From: Lauren Wiltshire [REDACTED]
Sent: 24 April 2019 13:43
To: Laura Gibbons <Laura.Gibbons@arun.gov.uk>
Cc: Simon Davis <Simon.Davis@arun.gov.uk>
Subject: RE: Planning Consultation on FP/42/19/DOC

Engineers Comments Regarding Condition 7

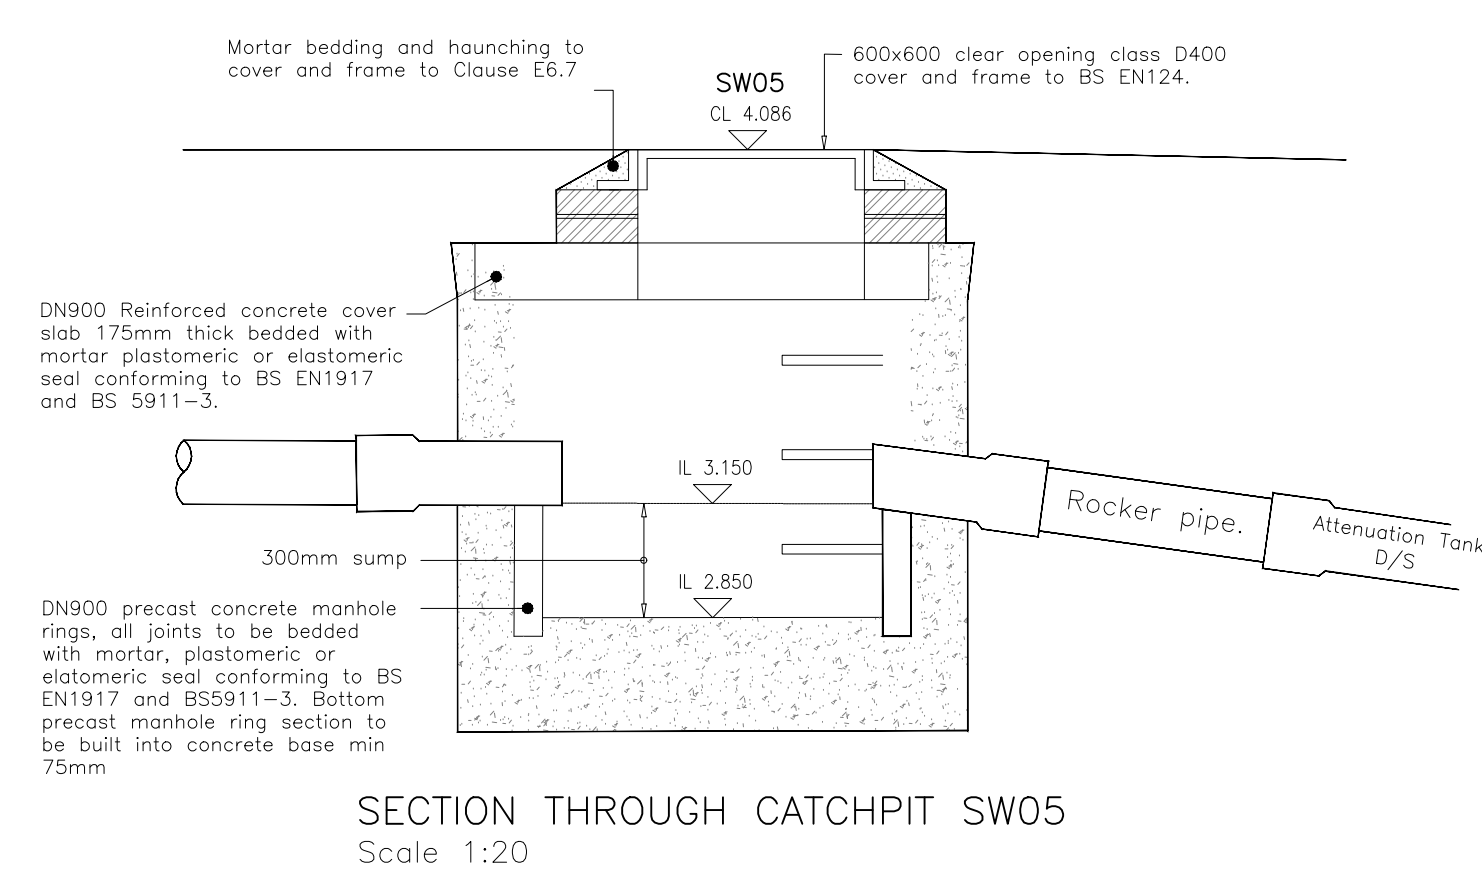
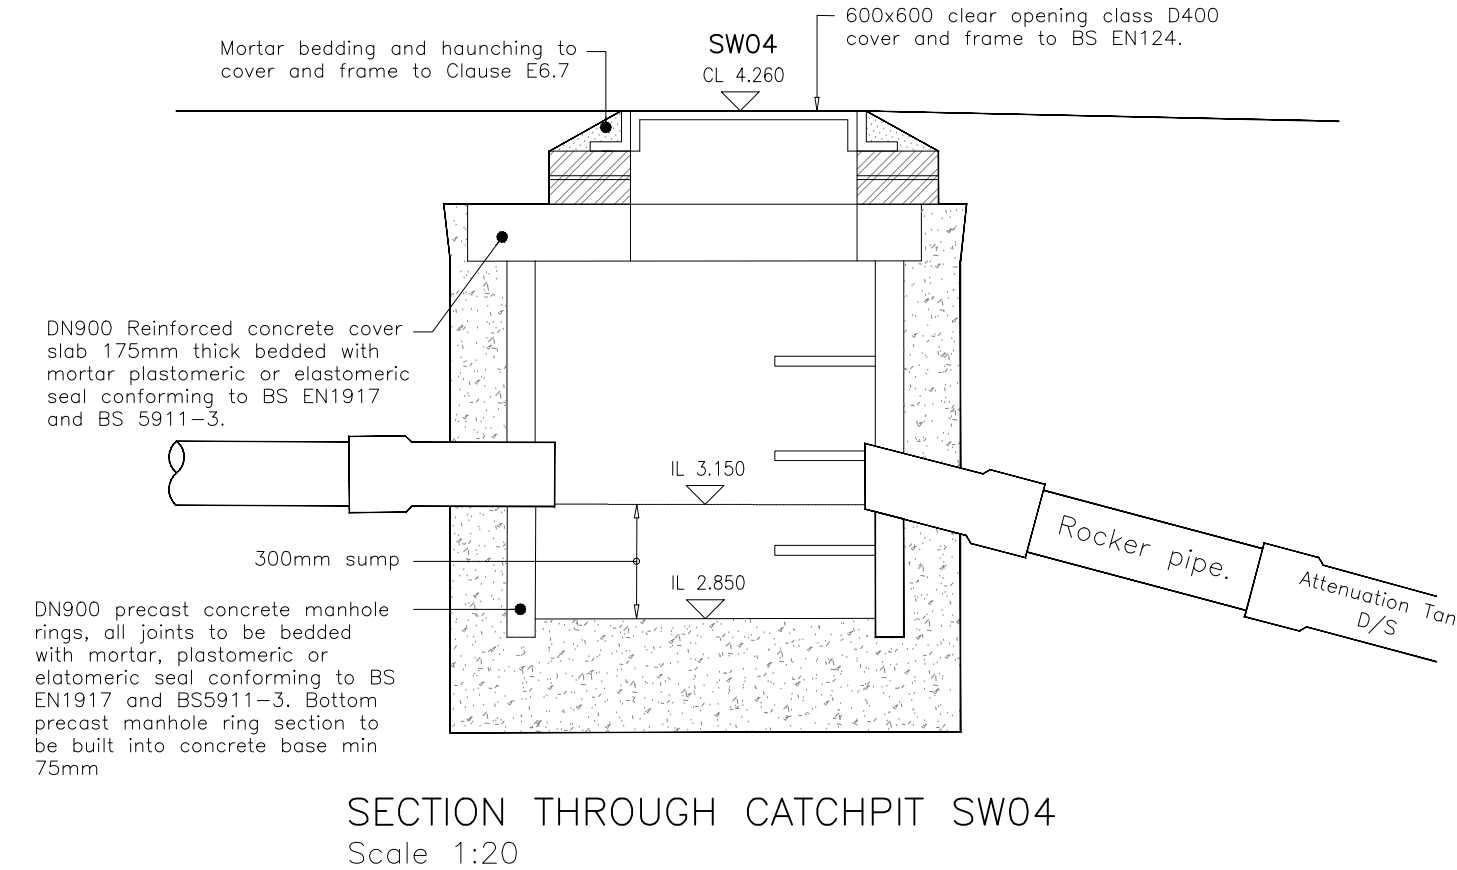
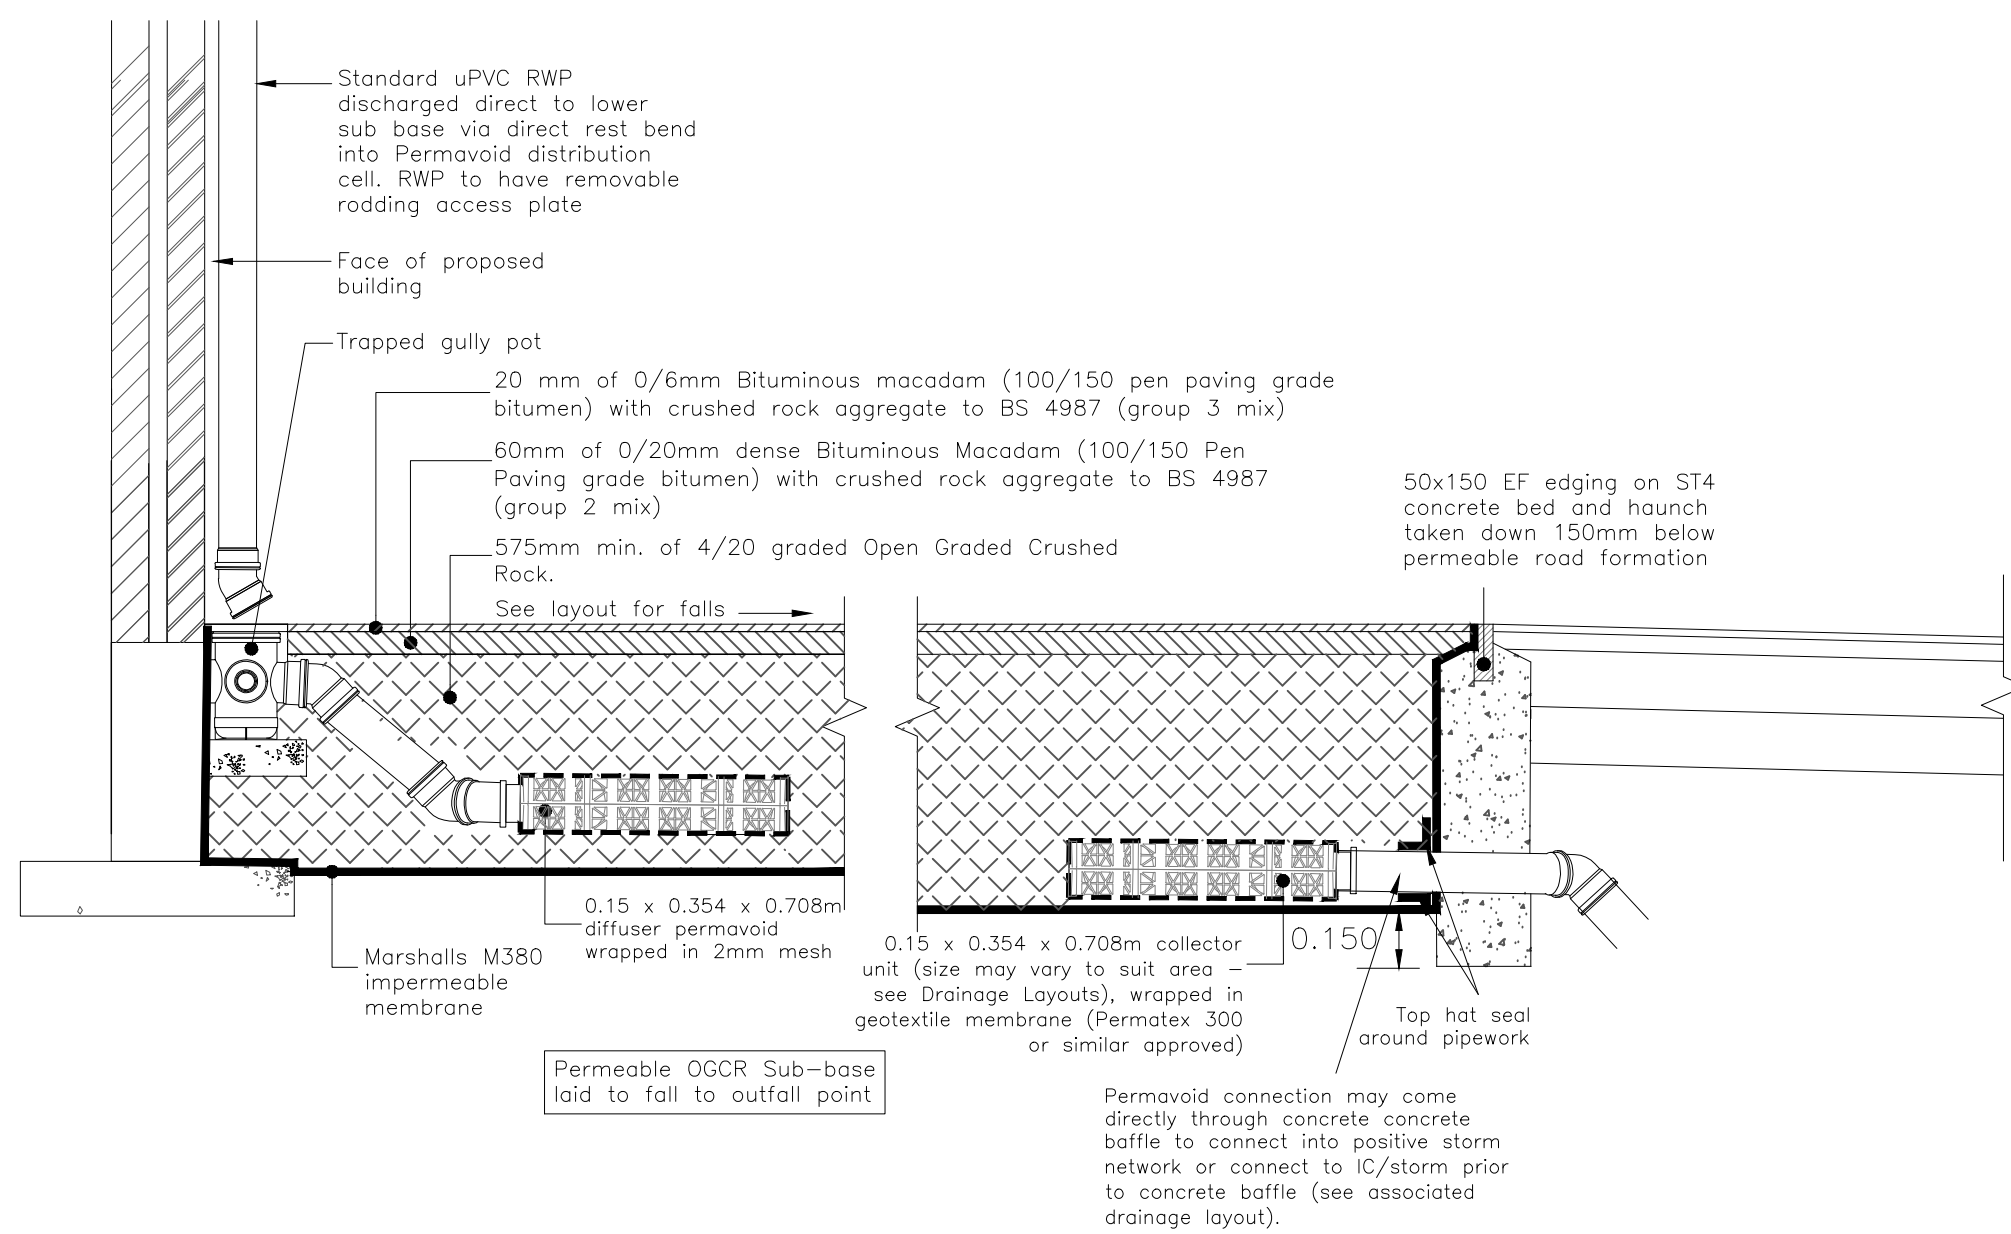
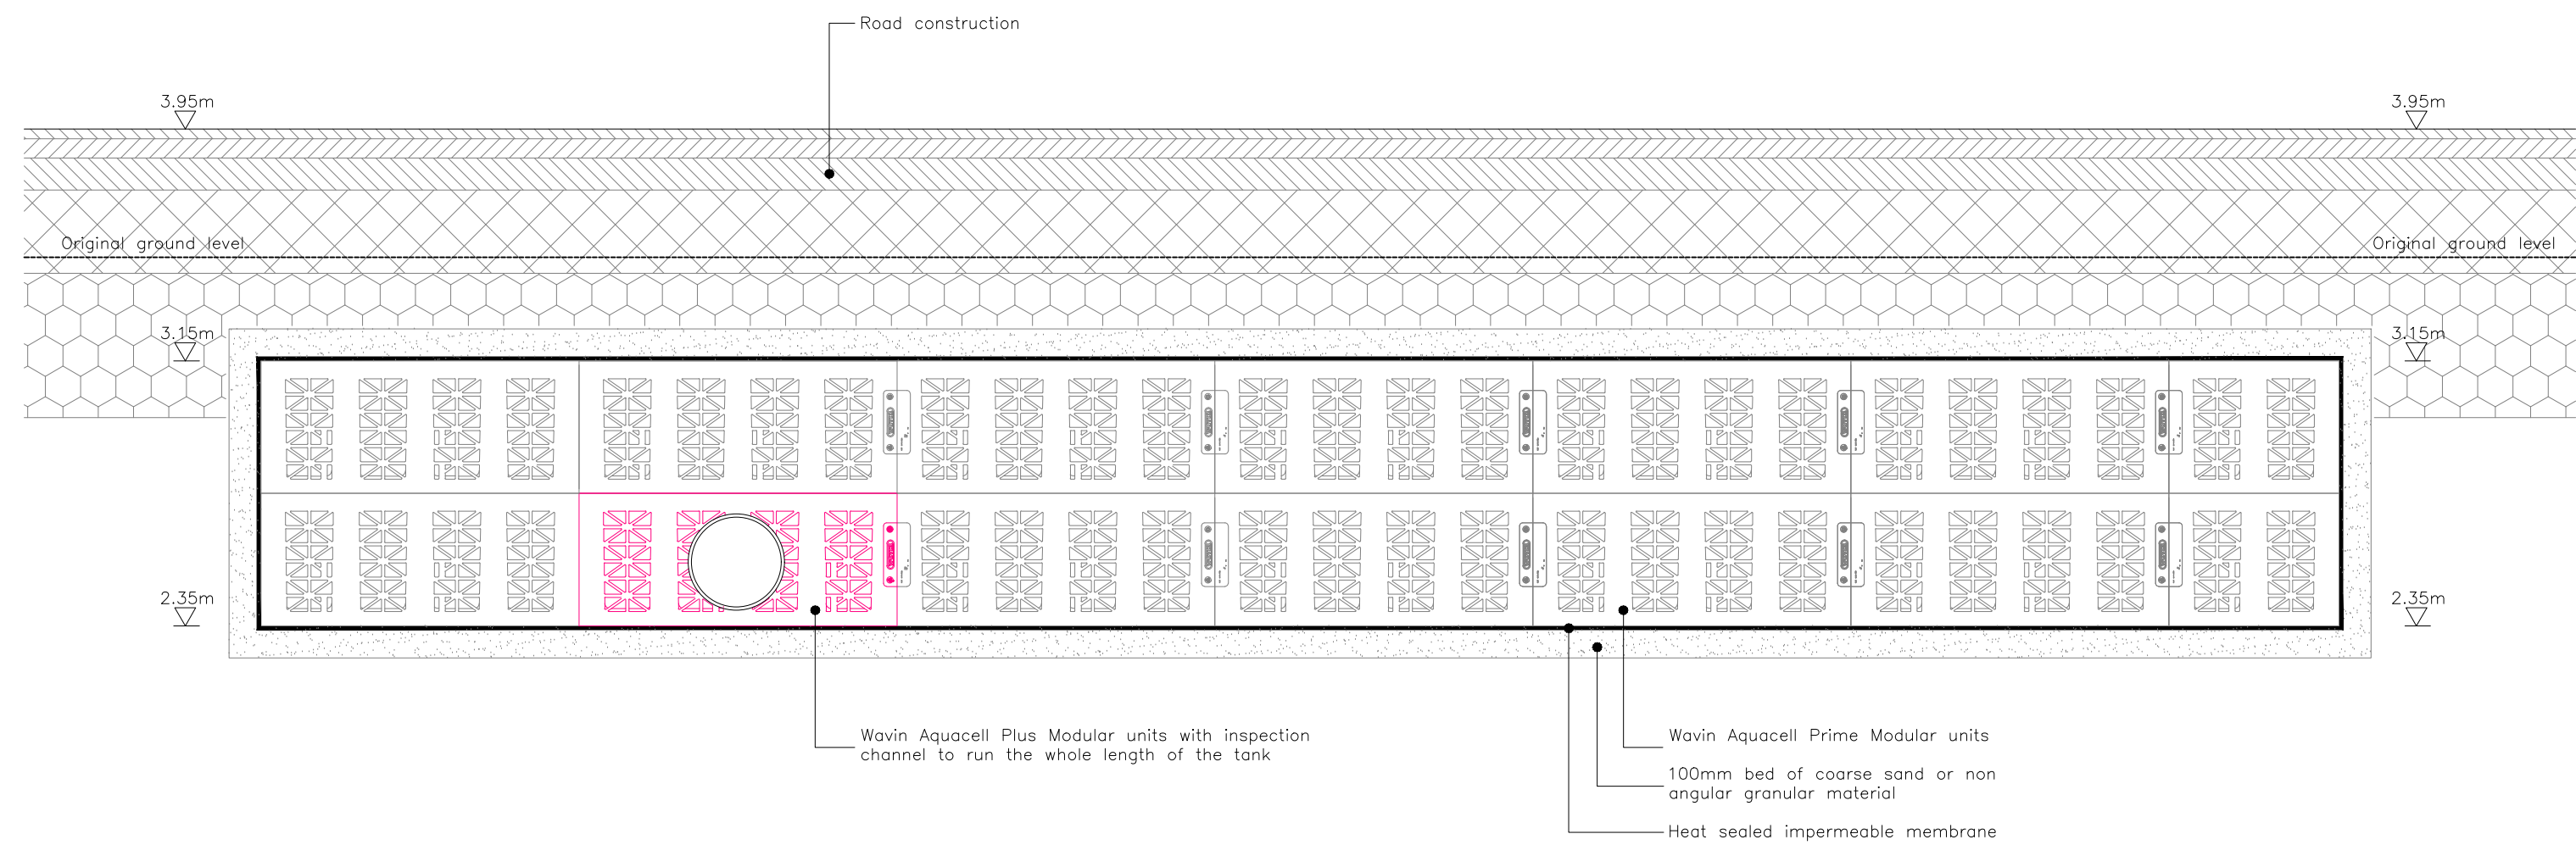
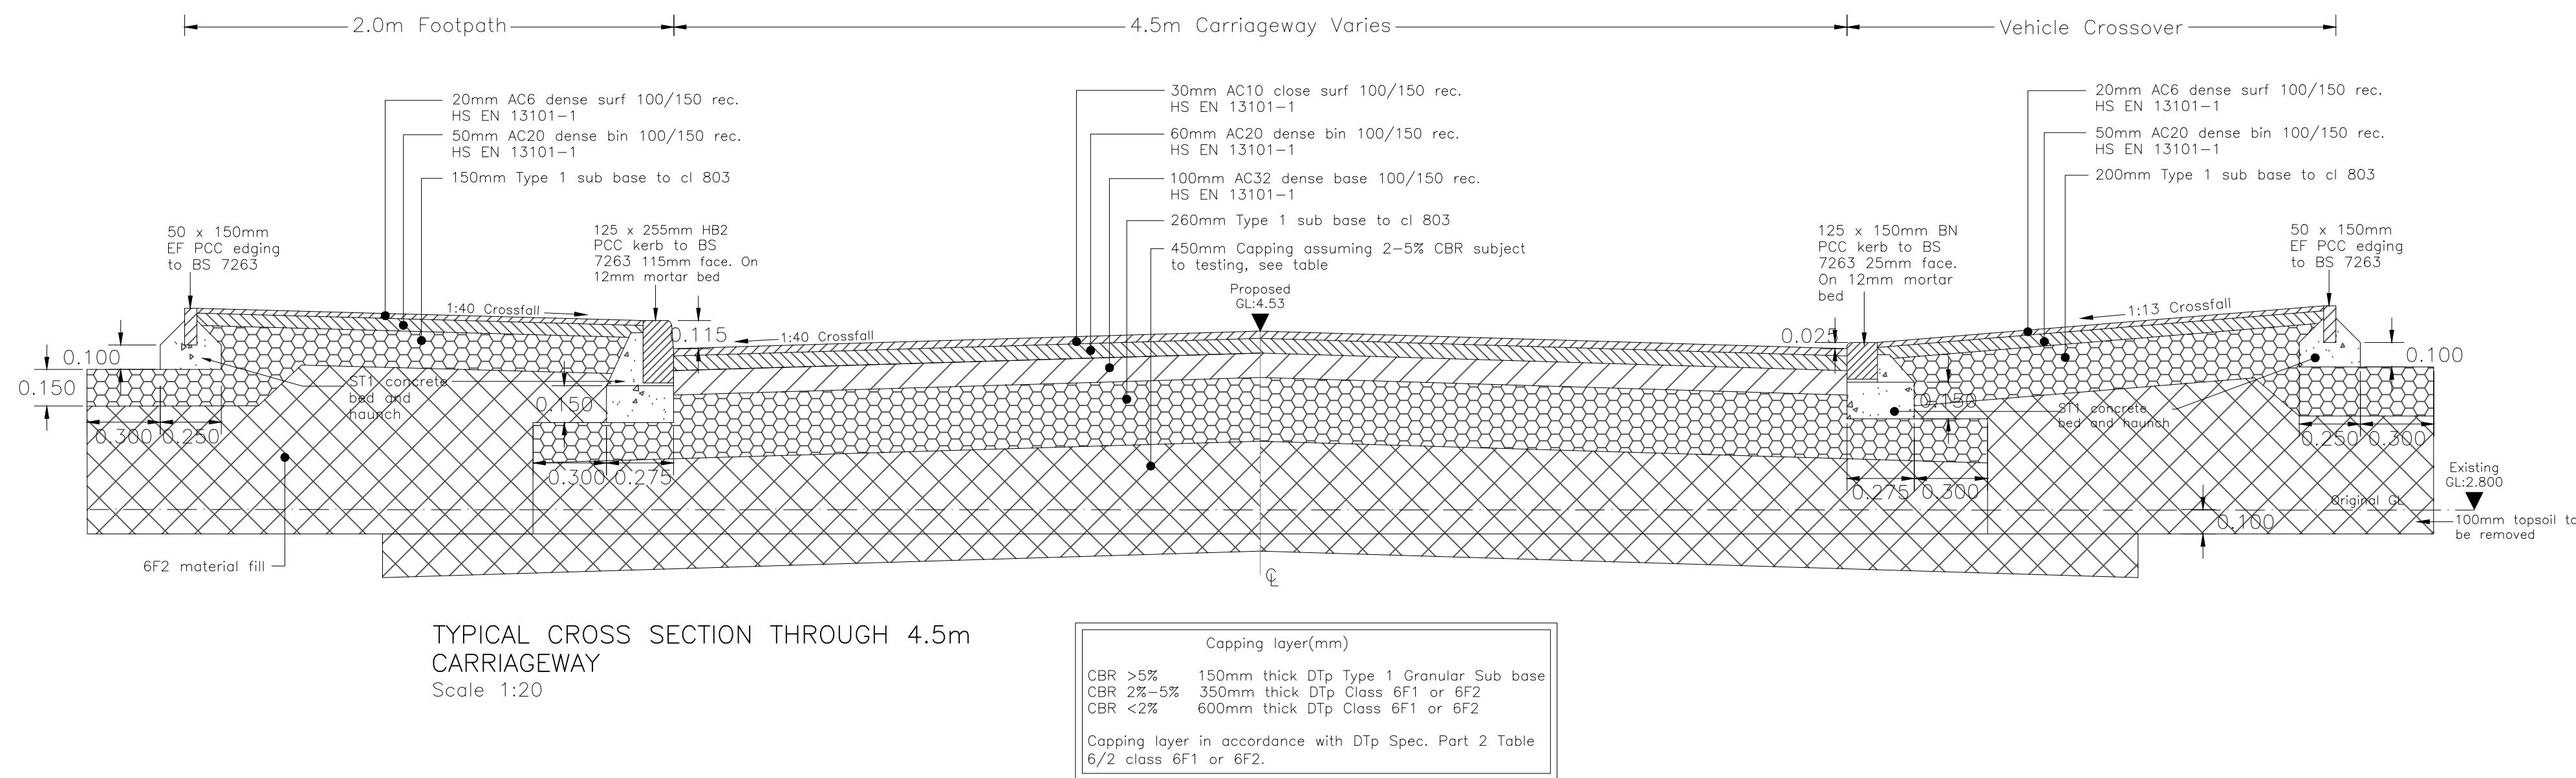
1. Catchpits must be provided upstream of all connections into the attenuation tank.
2. No construction detail drawings have been provided. Please provide construction detail drawings of manholes, catchpits, permeable paving, attenuation tank and hydrobrake.
3. There is conflict between the landscaping proposals and the drainage proposals. Trees must not be located on or near attenuation tanks. Please revise the landscaping proposals.
